From: Emma Penn [REDACTED]
Sent: 20 June 2019 12:10
To: Zac Denton <Zac.Denton@arun.gov.uk>
Subject: Planning App AB39 19 PL and AB40 19 PL Objection

In relation to the 2 applications mentioned in the subject header, the plans need to be re-submitted clearly outlining the demarcation internally (floorplans) and externally (courtyard) between residential and commercial usage. I should also like to enquire that if the changes are approved how the noise levels between both areas are to be controlled and also how this should effect the homes above the commercial areas?

SURVEY - GROUND FLOOR PLAN

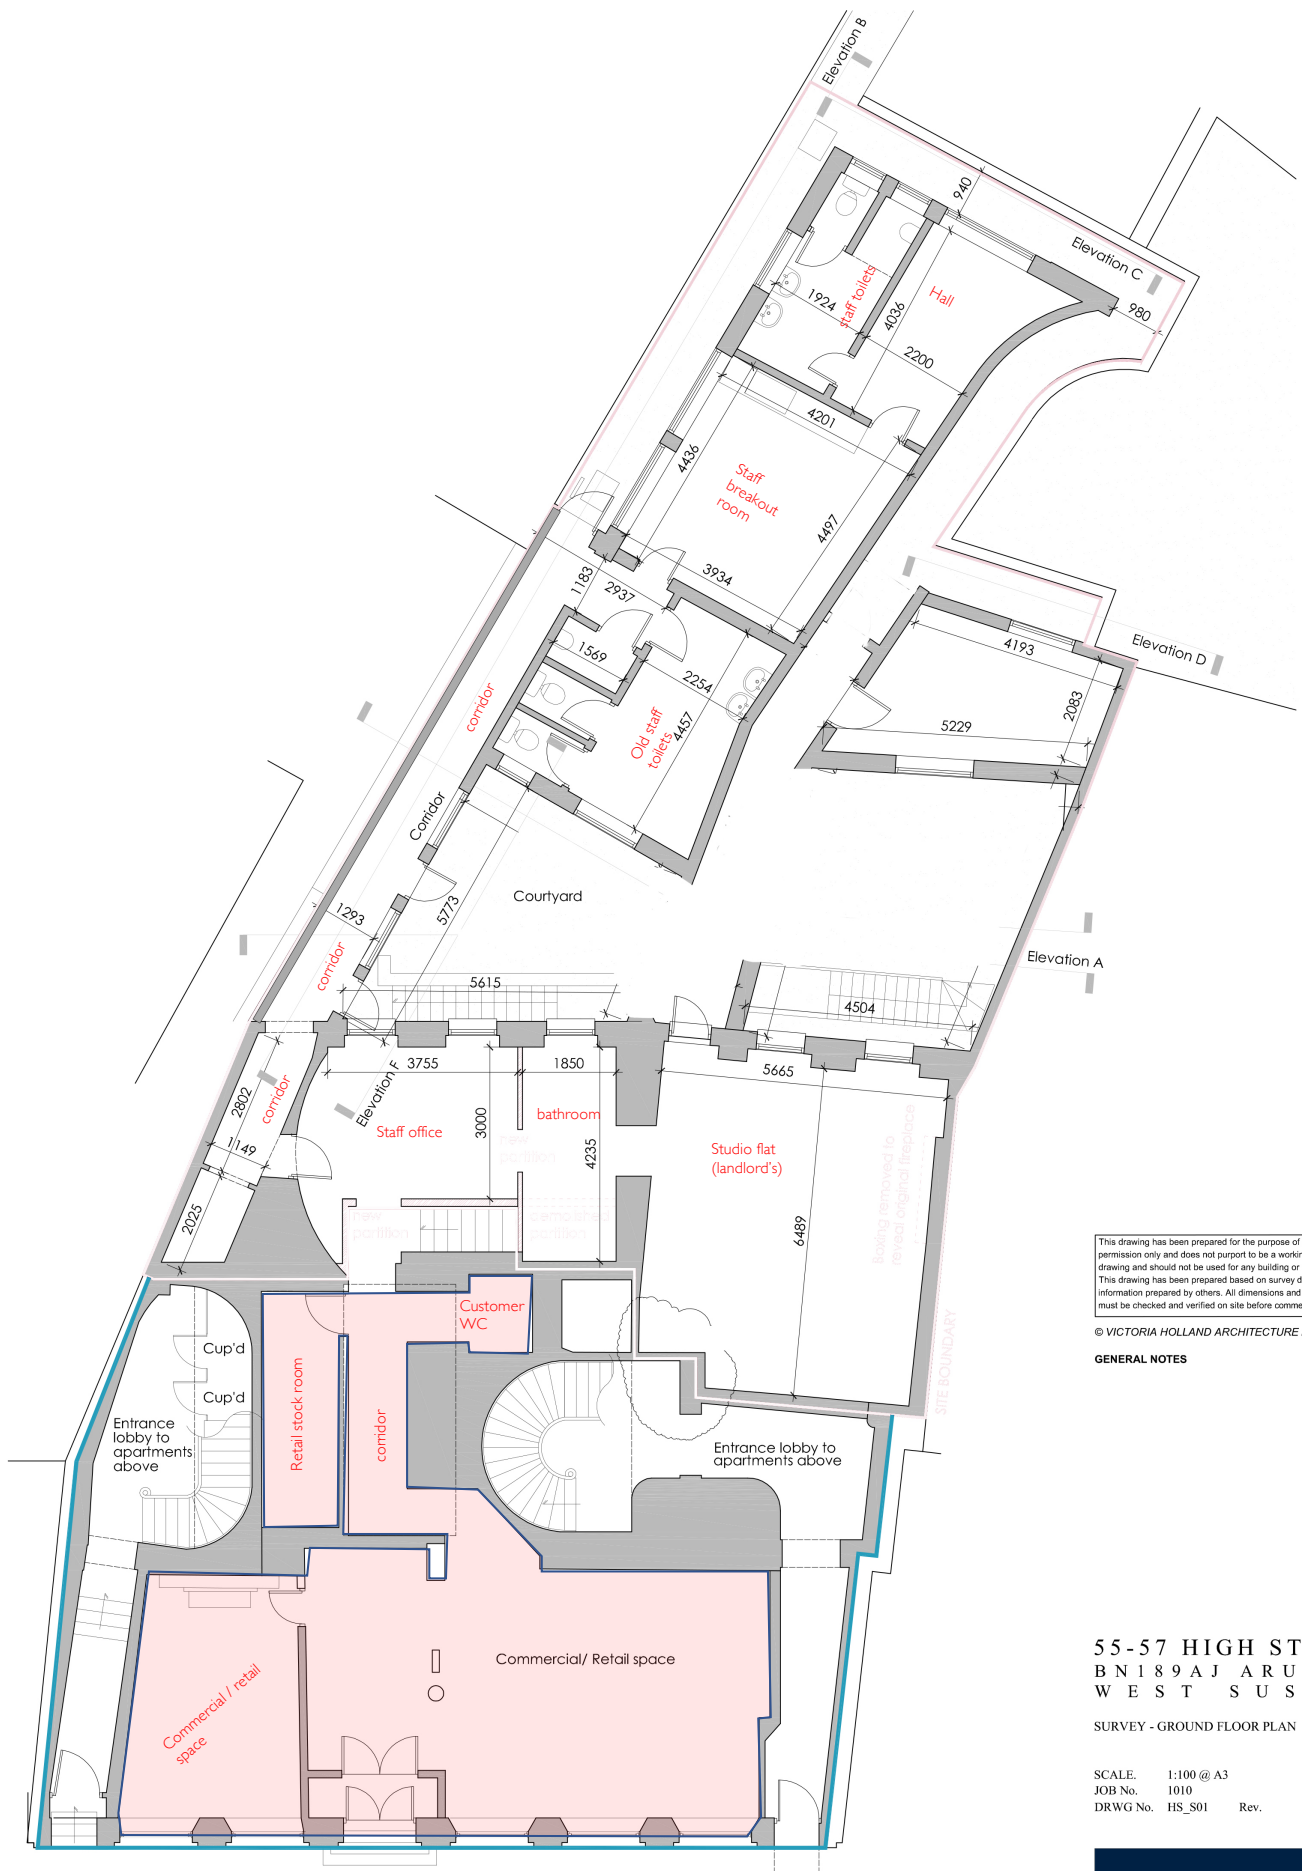
If the usage is changing from financial services to mixed use retail (for the retail of alcohol), please could you advise if the fire department have been consulted on additional safety precautions as there are 6 flats above some of which have no fire escape!
